**Application no:** H02-0902-09

**Description:** Ground floor extension and alterations

**Amendment:** Amended shape and size of rooflights (dwg. nos.  
2008-09-03B and 2008-09-04B)

### ACKNOWLEDGEMENT OF AMENDMENT

| 2008/09  | 03B         |

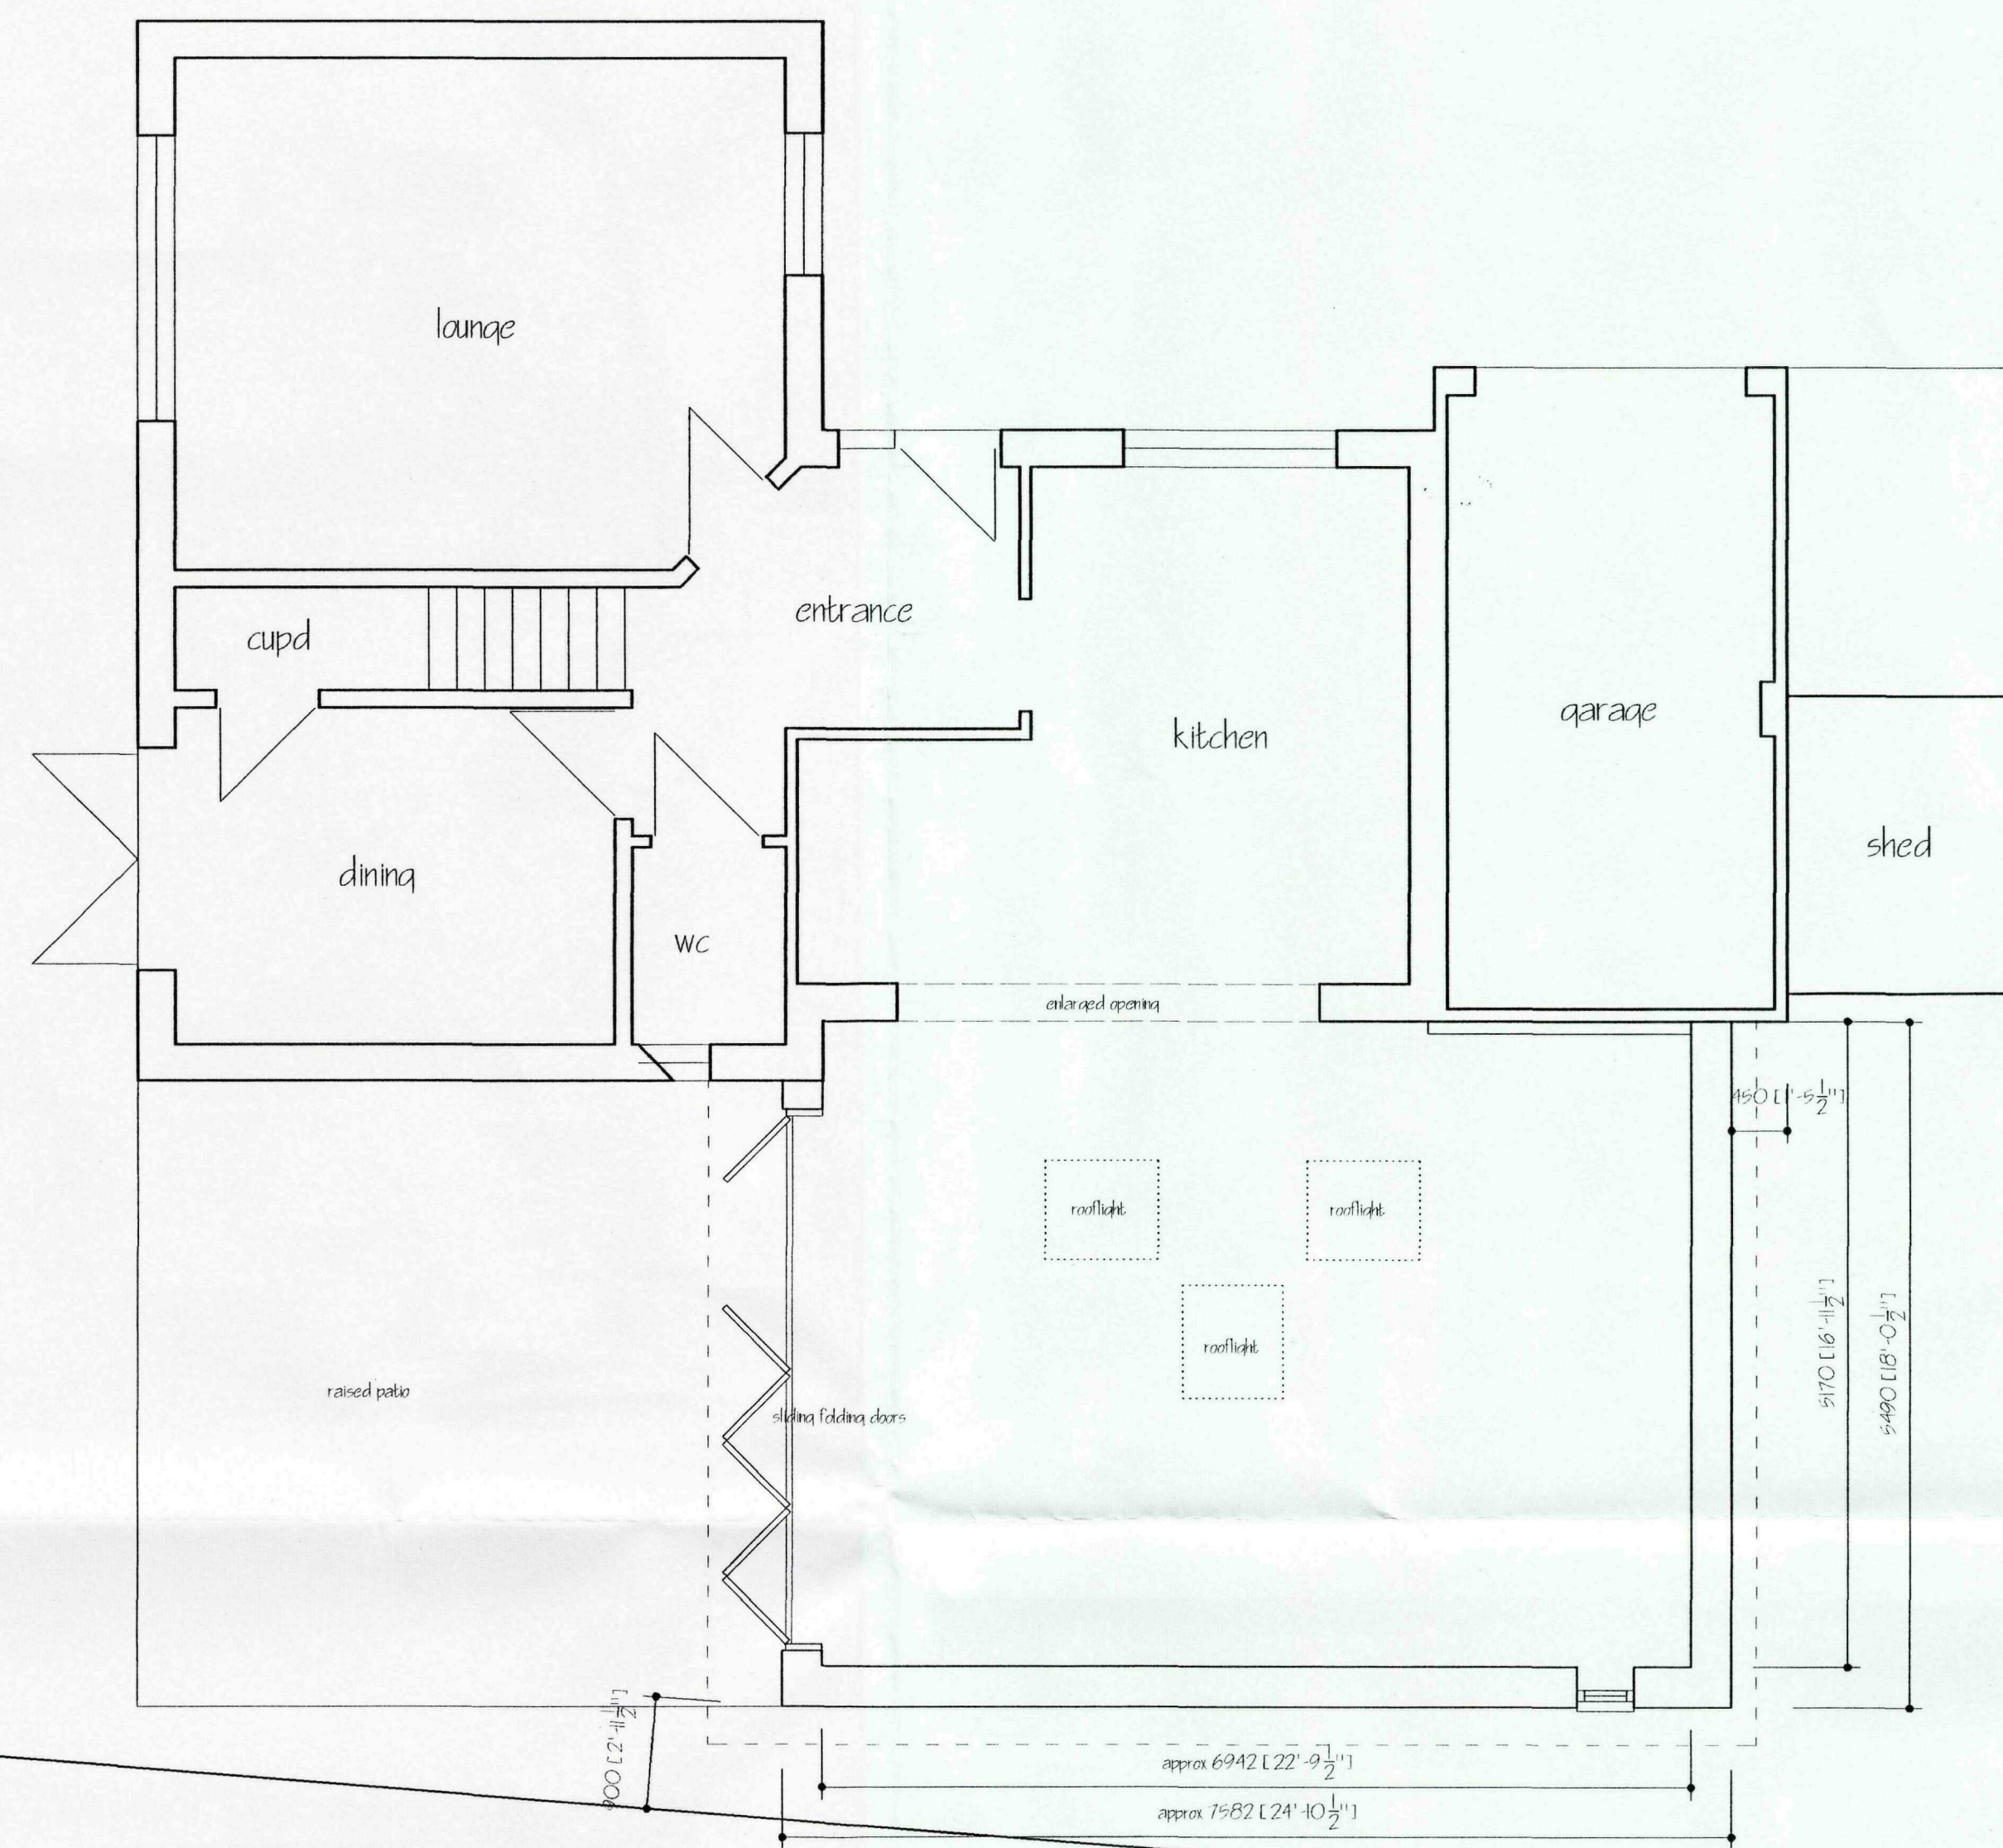
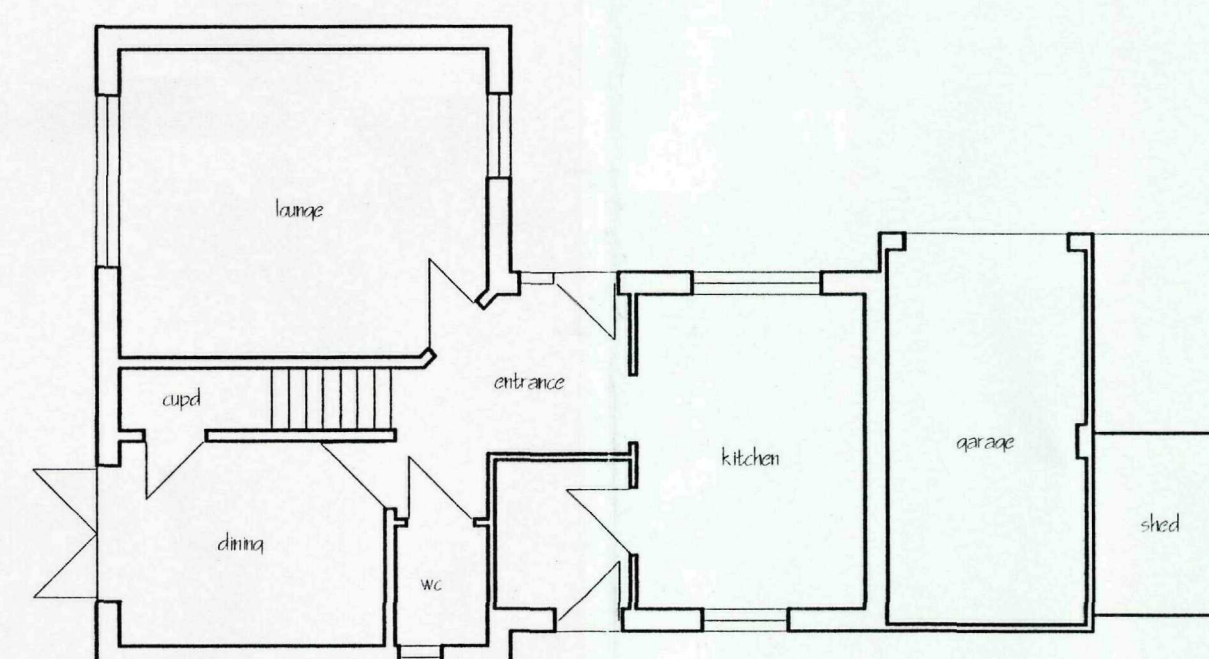
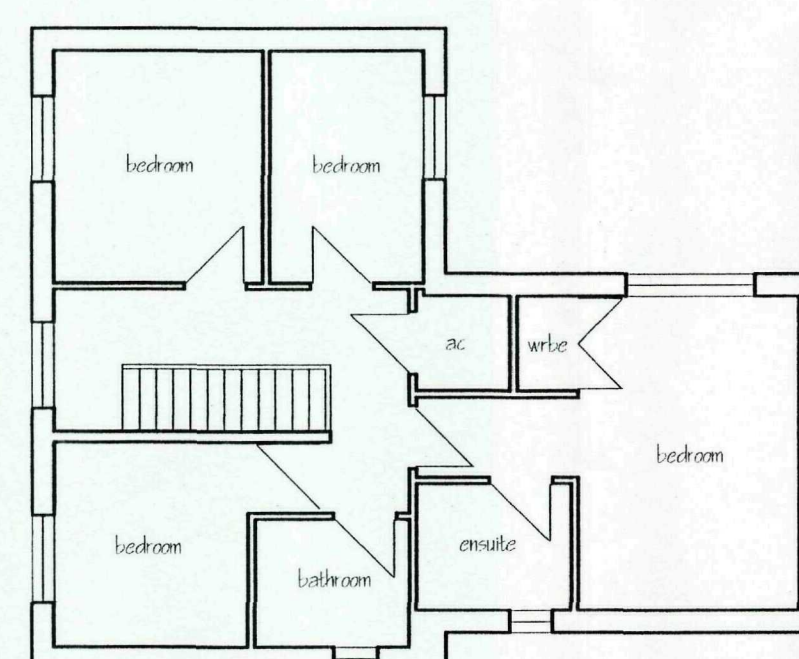
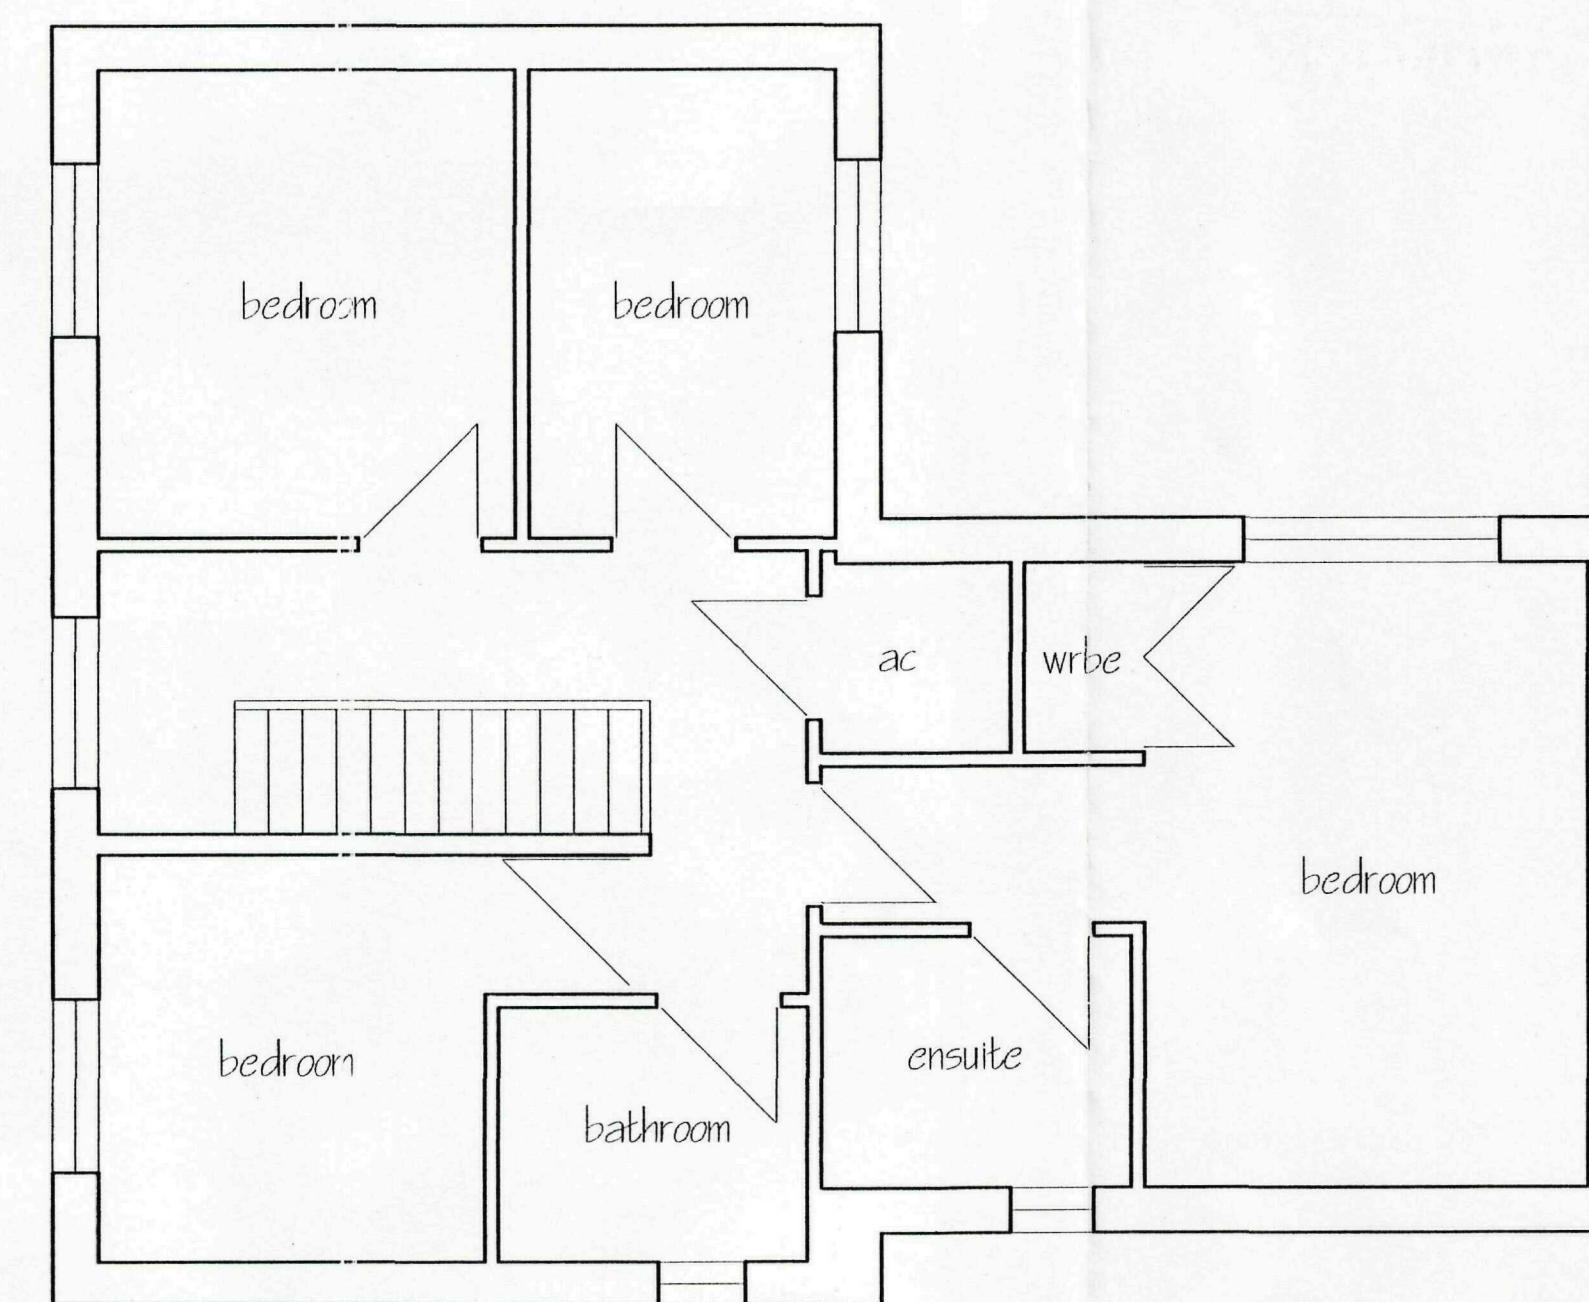
With reference to the above please find enclosed 2 No copies of amended plans as our clients have changed the shape and size of the rooflights on the extension.
